# Block 11, Central Park

MP 06\_0171 MOD 10 and SSD 6673

## Response to Submissions Table

WELLINGTON STREET
SHADOW ANALYSIS JULY 21

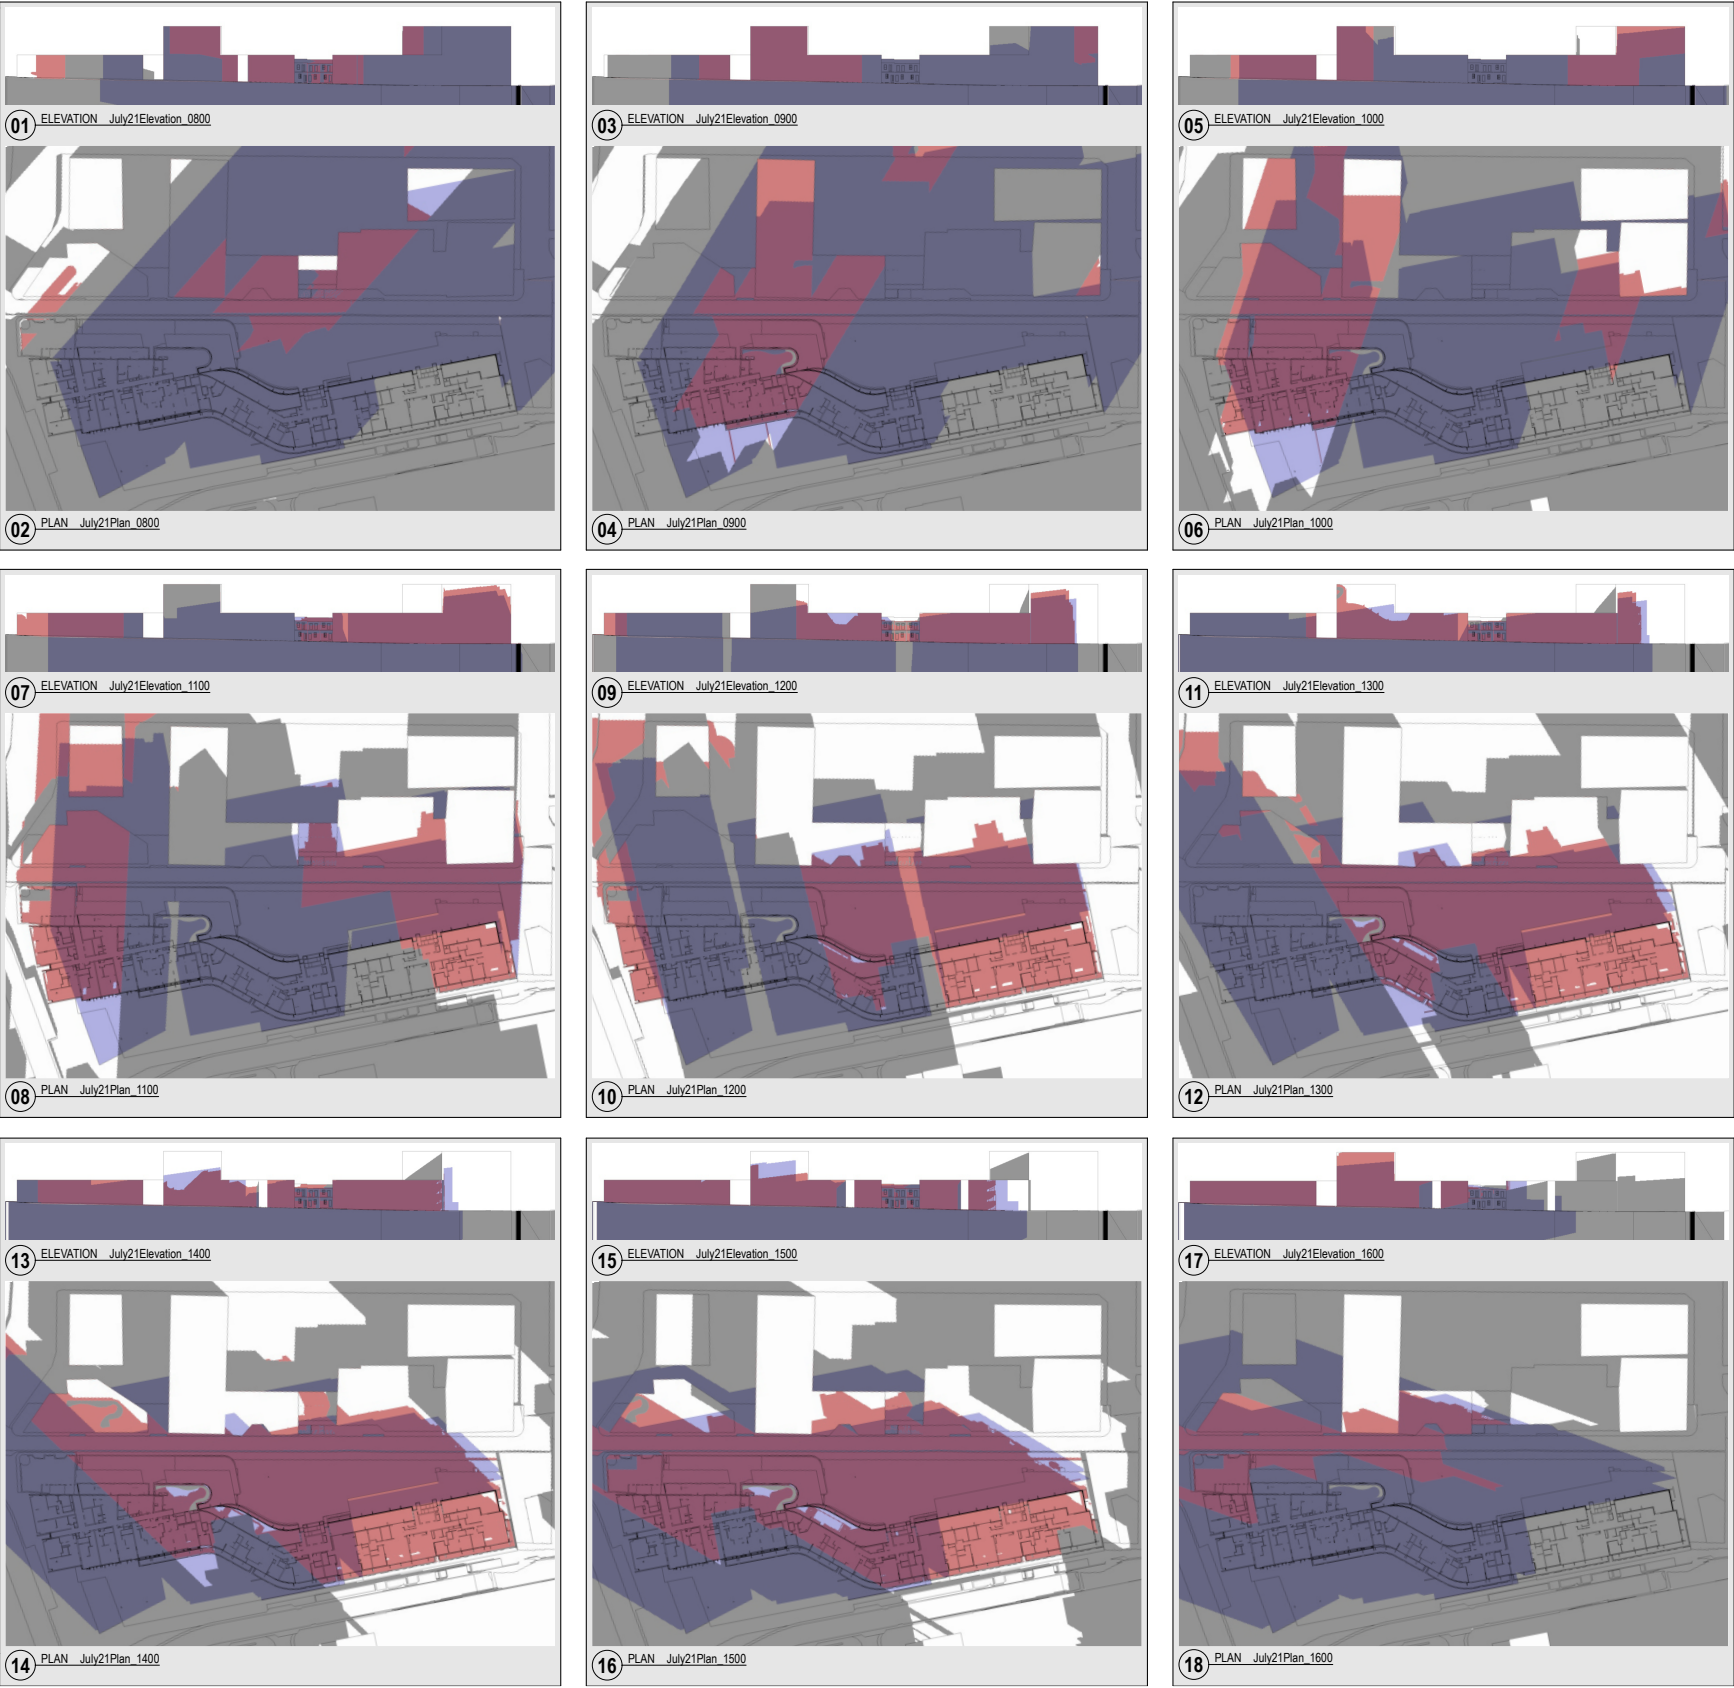
<b>Overshadowing</b>	
Concern has been raised regarding the potential overshadowing impact generated by the proposal, particularly in relation to dwellings on Wellington, O'Connor, Queen and Balfour Streets	<p>Refer to Section 2.11 – ‘Solar Access and Overshadowing’ of the RTS where this is discussed in detail.</p> <p>The project Architects FJMT have provided shadow diagrams and elevation of the building on Wellington Street for each hour between 8am and 4pm on the 21st day of every month. The following is noted from the plans:</p> <ul style="list-style-type: none"> <li>○ many of the buildings, particularly those identified as being residential, are largely affected by existing overshadowing from existing and surrounding buildings;</li> <li>○ some additional overshadowing in the morning of March and June; and</li> <li>○ more sunlight afforded to these building in August.</li> </ul>

Submission Item	Proponents Response
	<p>The results demonstrate improvement in the overall level of solar access afforded to the buildings fronting Wellington Street south of the site, when compared to the current approved Concept Plan.</p>
<b>Community Consultation Process</b>	
<p>Concern has been raised over the community consultation process undertaken in the pre-application phase.</p>	<p>As set out in Section 4 of the EIS submitted with the SSD, consultation was undertaken with various stakeholders, Department of Planning and Environment, Council and the broader public</p> <p>In addition to discussion with City of Sydney Council and the Department of Planning prior to lodgement, and following lodgement of the SSD, the following consultation was undertaken:</p> <p><b>Targeted Briefings</b></p> <ul style="list-style-type: none"> <li>On 30 May 2014 from 11:00am-12:45pm a briefing was held with the Chippendale Residents Interest Group. This was attended by five members of the Group, including a resident from one of the terraces located on Wellington Street.</li> <li>On 16 June 2014 from 2:00pm-3:00pm a briefing was held with the University of Technology Sydney. This was attended by three officers of the University.</li> </ul> <p><b>Community Information and Feedback Session</b></p> <ul style="list-style-type: none"> <li>This was held on Saturday 31 May 2014 from 10am to 1pm in an office at Central Park, 7 Carlton Street, Chippendale. The session featured two short presentations by the project architect at 10:30am and 11:30am.</li> </ul> <p>Presentation material was uploaded to the Central Park website and YouTube channel shortly after the information session to allow members of the community to review information further as part of their submissions.</p> <p>A summary of the outcomes/items raised during the consultation described above, as well as the proponent's response and where these items have been addressed in this report and accompanying consultant reports. The details response table is provided as part of the Consultation Report submitted with the SSD.</p>
